Subject: RE: Planning Consultation on: A/266/21/PL

Engineers Comments Regarding Surface Water Drainage

Application No: A/266/21/PL
Registered: 31st January 2022
Site Address: Crete House The Beeches Dappers Lane Angmering BN16 4EN
Grid Reference: 507291 104939
Description of Works: 2 No. 2 storey extensions, replace existing bay window with bi-fold doors on the existing dwelling and the construction of 2 No. 5 bed new dwellings. This application is in CIL Zone 2 and is CIL liable as new dwellings.

SITE PLAN & VISIBILITY SPLAY
1:200

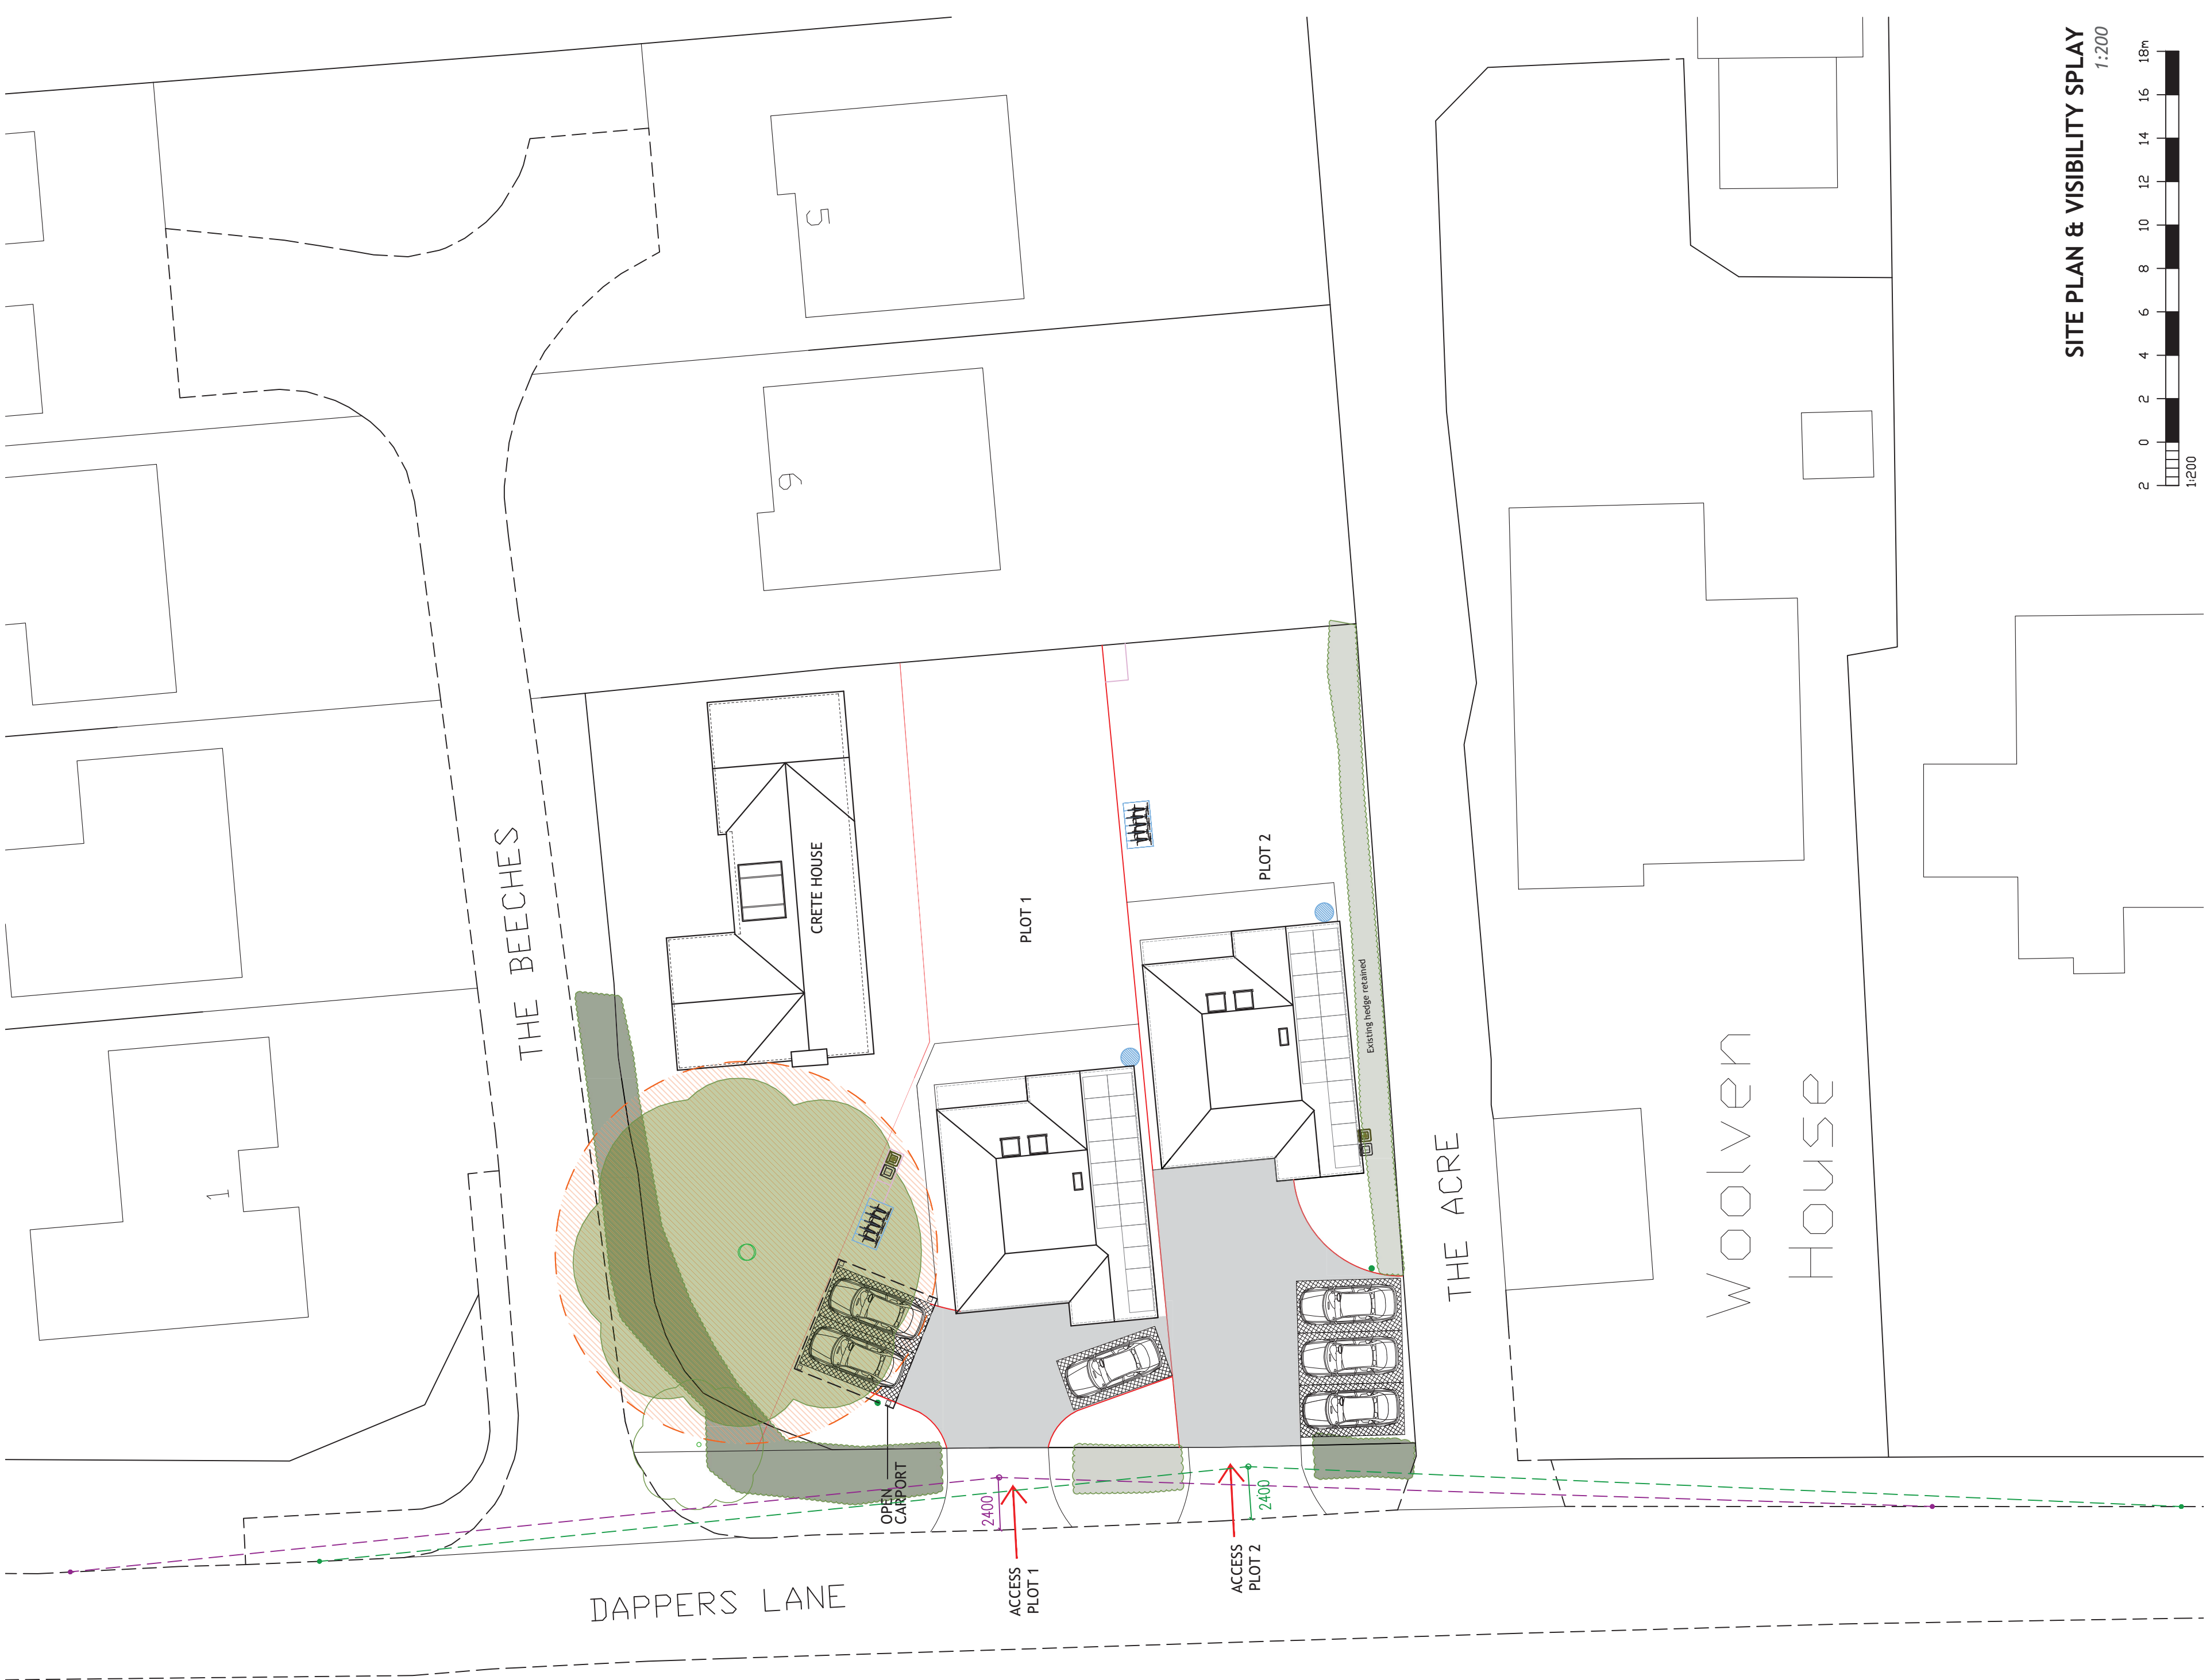
No flood risk assessment (FRA) or drainage design has been provided to support this application. Much of the site is at risk of surface water flooding, with an area in the location of the proposed house for Plot 2 at risk of surface water flooding in a 1 in 100 year storm event (with no allowance for climate change). Paragraph 167 of the National Planning Policy Framework states that local planning authorities should ensure that flood risk is not increased as a result of a proposed development. Footnote 55 states that in "flood zone 1 an assessment should accompany all proposals involving (...) land that may be subject to other sources of flooding, where its development would introduce a more vulnerable use." The introduction of two new dwellings in an area which was formerly a garden will introduce a more vulnerable use and will be in an area subject to other sources of flooding (surface water).

Therefore I wish to lodge a holding objection to this application. To overcome my objection the applicant should provide an FRA that takes account of the surface water flood risk on the site and shows that flood risk will not be increased on or offsite as a result of the proposed development. If the site layout is to remain unchanged then compensatory storage for the lost surface water flood area may need to be provided.

If the FRA is provided and is satisfactory then the applicant should be aware that the proposed new dwellings have adequate space for containing a soakaways in their rear gardens. However, the proposed development will likely disrupt the existing surface water drainage for Crete House. Therefore we would expect to see a surface water design for the whole site, including the extended Crete House. The surface water drainage for Crete House will likely need to be located to the north of the house under the driveway as existing and proposed trees (root protection zones) must not conflict with suds features/pipework.

If you are minded to approve the application despite my holding objection please apply the following conditions to ensure that the development is adequately drained and does not increase flood risk elsewhere.

“Development shall not commence, other than works of site survey and investigation, until full details of the proposed surface water drainage scheme have been submitted to and approved in writing by the Local Planning Authority. The design should follow the hierarchy of preference for different types of surface water drainage disposal systems as set out in Approved Document H of the Building Regulations, and the recommendations of the SuDS Manual produced by CIRIA. Winter groundwater monitoring to establish highest annual ground water levels and winter Percolation testing to BRE 365, or similar approved, will be required to support the design of any Infiltration drainage. No building / No part of the extended building shall be occupied until the complete surface water drainage system serving the property has been implemented in accordance with the agreed details and the details so agreed shall be maintained in good working order in perpetuity.”
